From: Amanda Scholes on behalf of Planning.Responses
Sent: 25 February 2020 10:55
To: Planning Scanning
Subject: FW: Decision Notice DOC Individual Actual PLDNDOCIACT [14 Coastal Road]
Attachments: 1724 PL1-06L-Proposed First Floor Plan.pdf; 1724 PL1-07H-Proposed Second Floor Plan.pdf; 1724 PL1-09D-Proposed Elevations.pdf; 1724 PL1-10E-Proposed Elevations.pdf

K/2/20/DOC

From: sarah hufford [REDACTED]
Sent: 25 February 2020 09:39
To: Anita Gardner [REDACTED]
Subject: Re: Decision Notice DOC Individual Actual PLDNDOCIACT [14 Coastal Road]

REV.	DATE	DESCRIPTION
PROJECT		
14 COASTAL ROAD EAST PRESTON BN16 1SJ		
DRAWING		
PROPOSED EAST & SOUTH ELEVATIONS		
CLIENT		
MRS & MR CLARKE		
SCALE	DRAWN	
1:50 @ A1 / 1:100 @A3		
DATE	CHECK	
FEBRUARY 2020		
DRAWING No.	REVISION	
1714- PL1-09	D	
© copyright retained

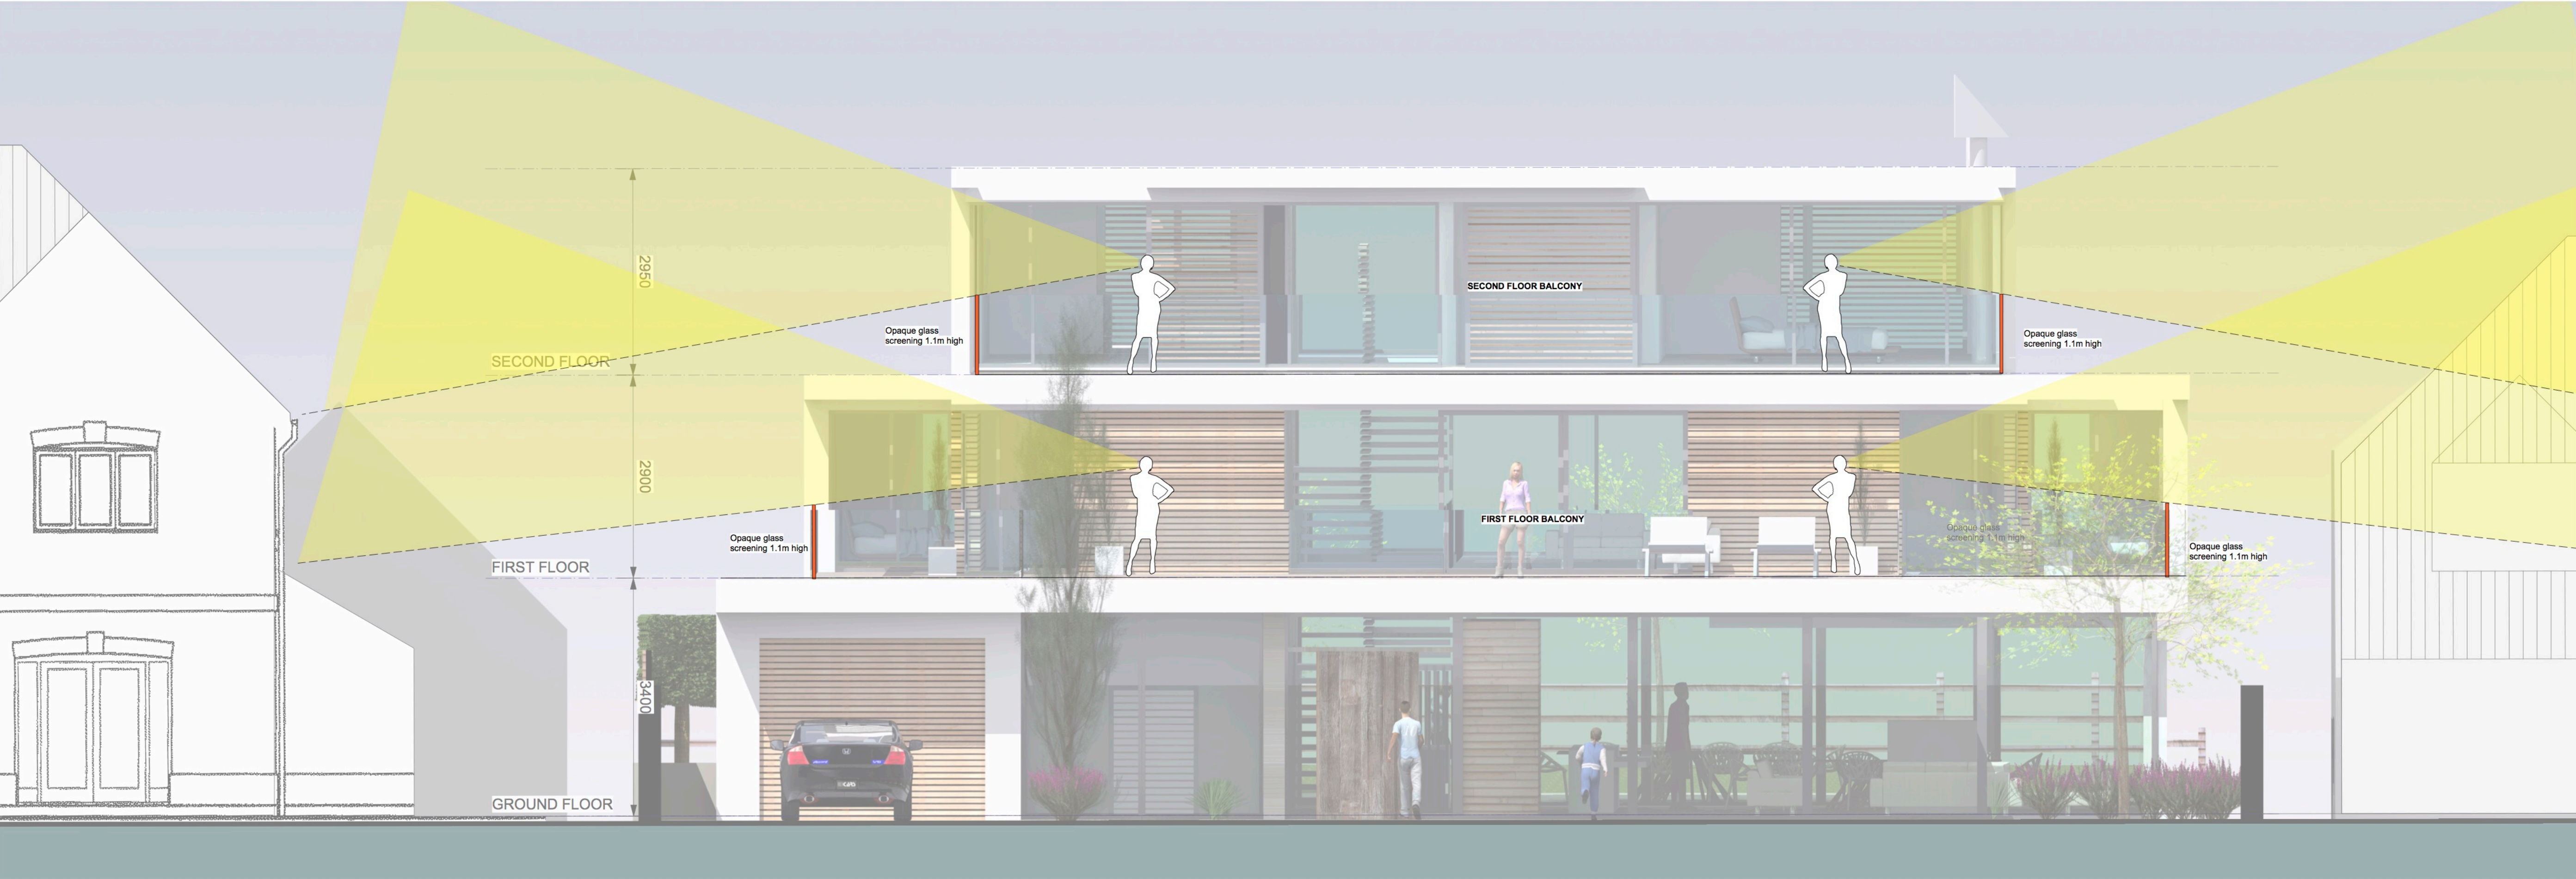
Hi Sarah,
To speed up the discussion process and to avoid any confusion can you submit first and second floor layout plans with the extent and height of balcony screening to the east and west elevations clearly marked.
Regards
Anita

The other condition is not covered by the decision notice a separate letter will be issued shortly, but I need to discuss the submitted information with my Team Leader first. I am not sure that the sides are sufficiently high.

As requested, herewith the elevations and plans showing the balcony screening requested - If there are any issues, please can you call to discuss [REDACTED]

When you speak to your Team Leader, please could you advise him that my client has been advised that higher balconies are not advised because of the high winds experienced here. The approved plans also show the balcony screens to 1.1m high. This is considered acceptable because the balconies are placed to the frontage of the building and over look open, front gardens with low dwarf walls at their front boundary, rather than private, rear spaces where, ordinarily higher levels of privacy are experienced. The only rear balcony is also adjacent to an area used for car parking.
